Recommendation Report for Planning Permission for Works or Extension to a Dwelling

REF NO: K/40/21/HH

LOCATION: 41 Coastal Road
East Preston
BN16 1SN

PROPOSAL: Replacement sun room with associated internal alterations

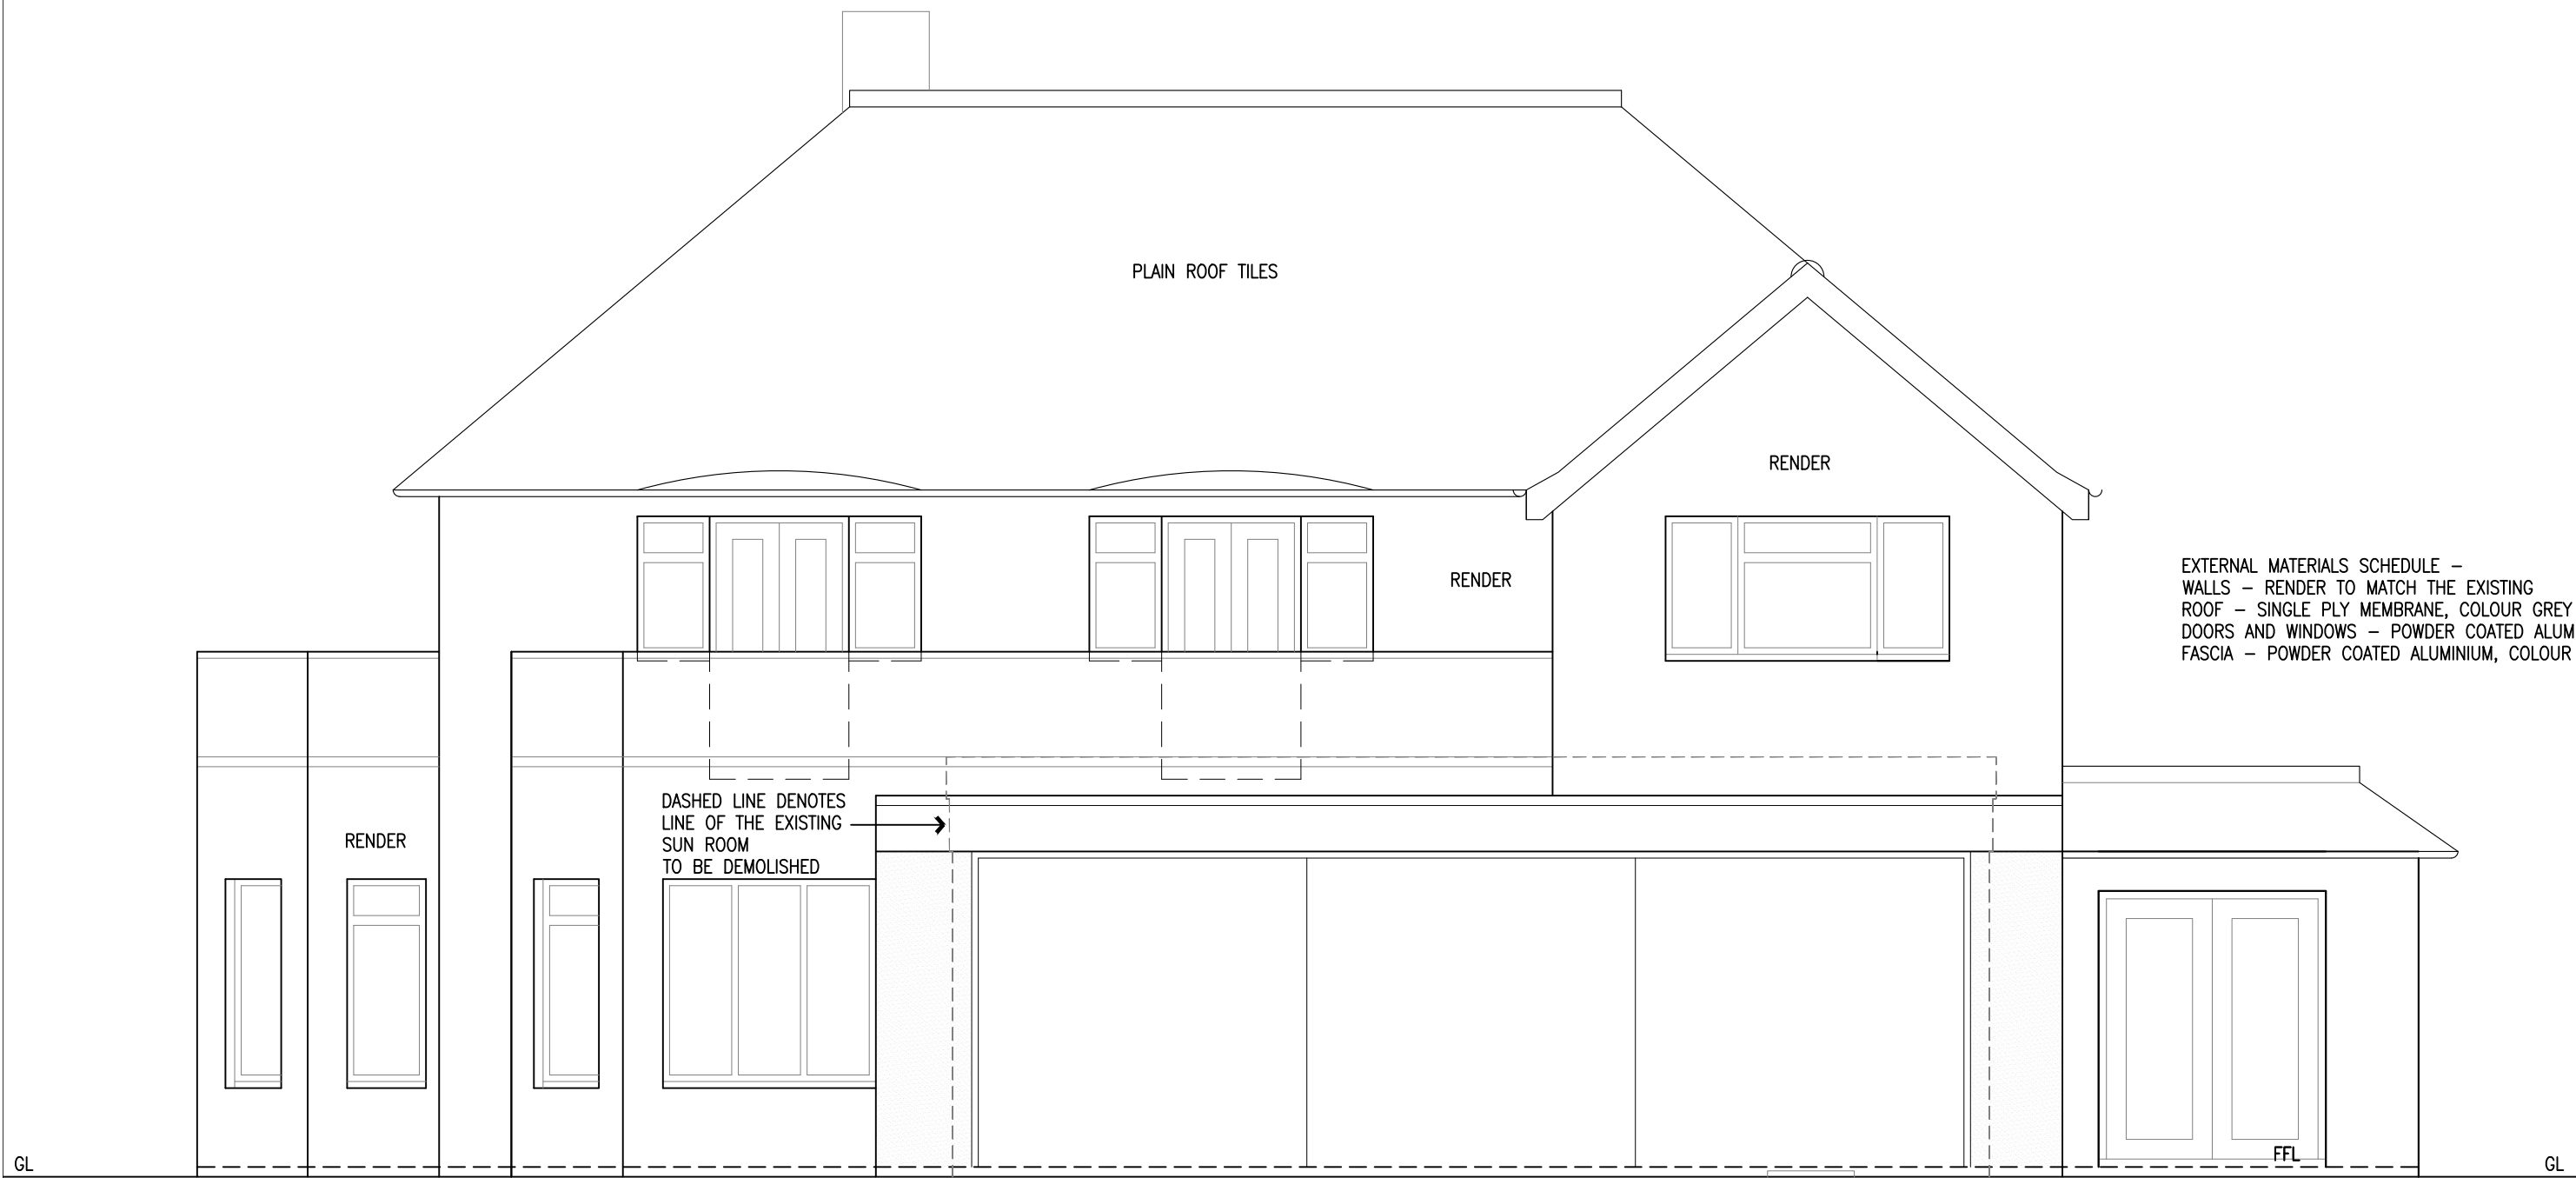
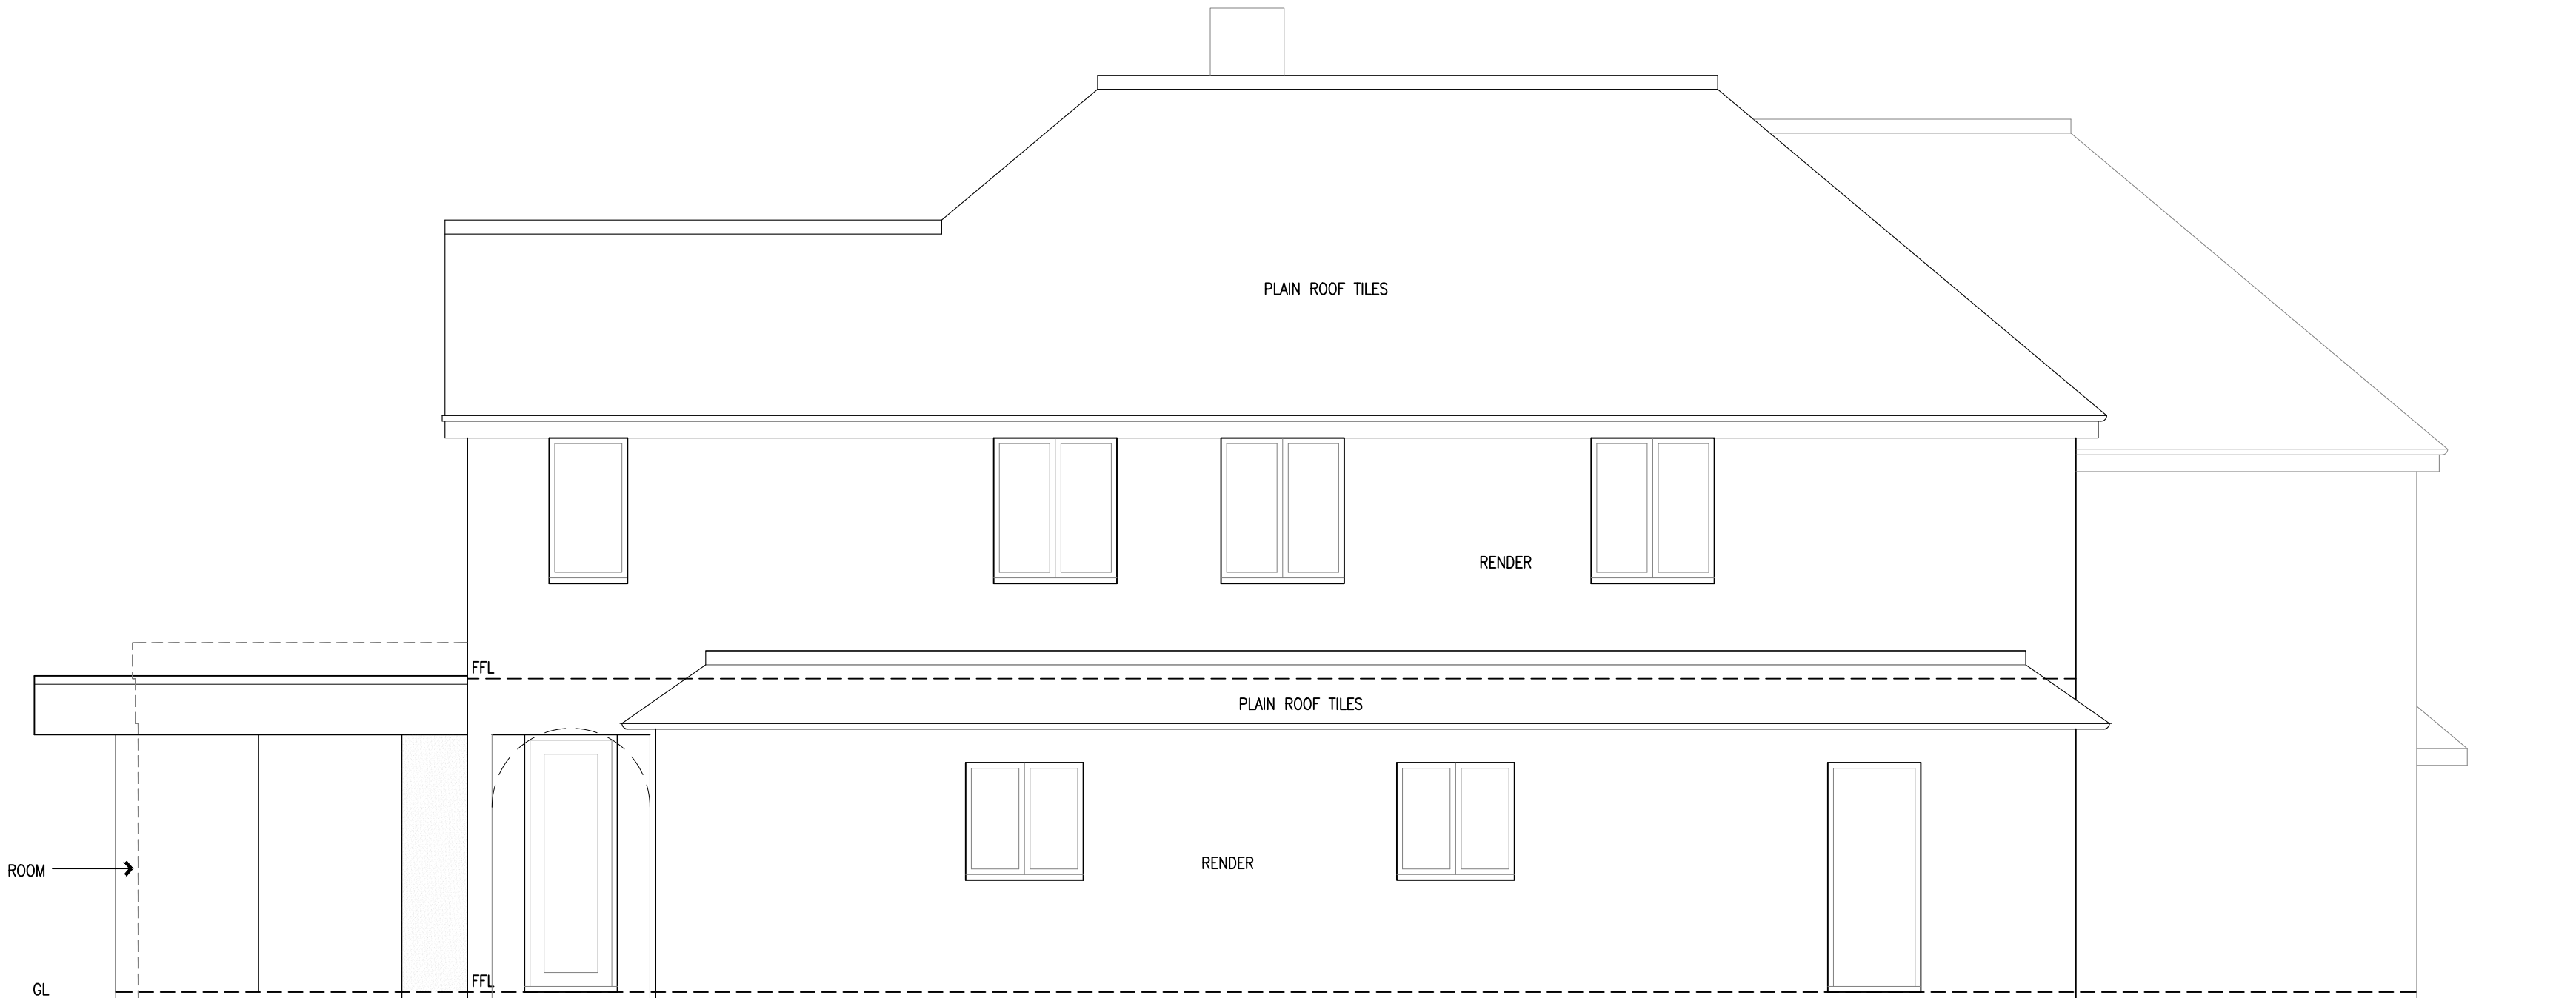
The proposed materials are considered to be complementary to the host dwelling in that the proposed render will match the existing dwelling affording the extension good visual integration.

It has been proposed to glaze the extension to 3 sides, with large panes of glass. At ground floor level however, it is generally accepted, that there will be no negative impacts from overlooking.
